Charlotte-Mecklenburg Planning, Design, & Development

SUBJECT: Administrative Approval for Petition No. 2019-062 Suncrest Real Estate and Land

REZONING ADMINISTRATIVE AMENDMENT PETITION 2019-062

CONDITIONAL REZONING PLAN

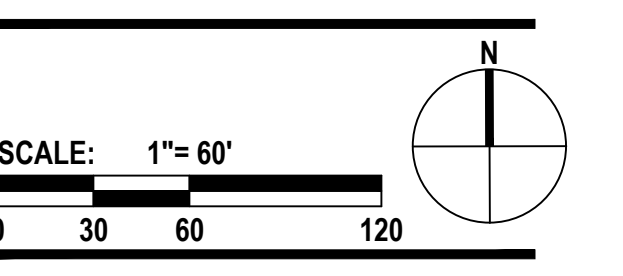
- Modification to the overall site plan to adjust proposed road network and remove a proposed road out of the railroad right-of-way.

- The site plan complies with the conditional notes and still meets the intent of the original approval by the City Council.
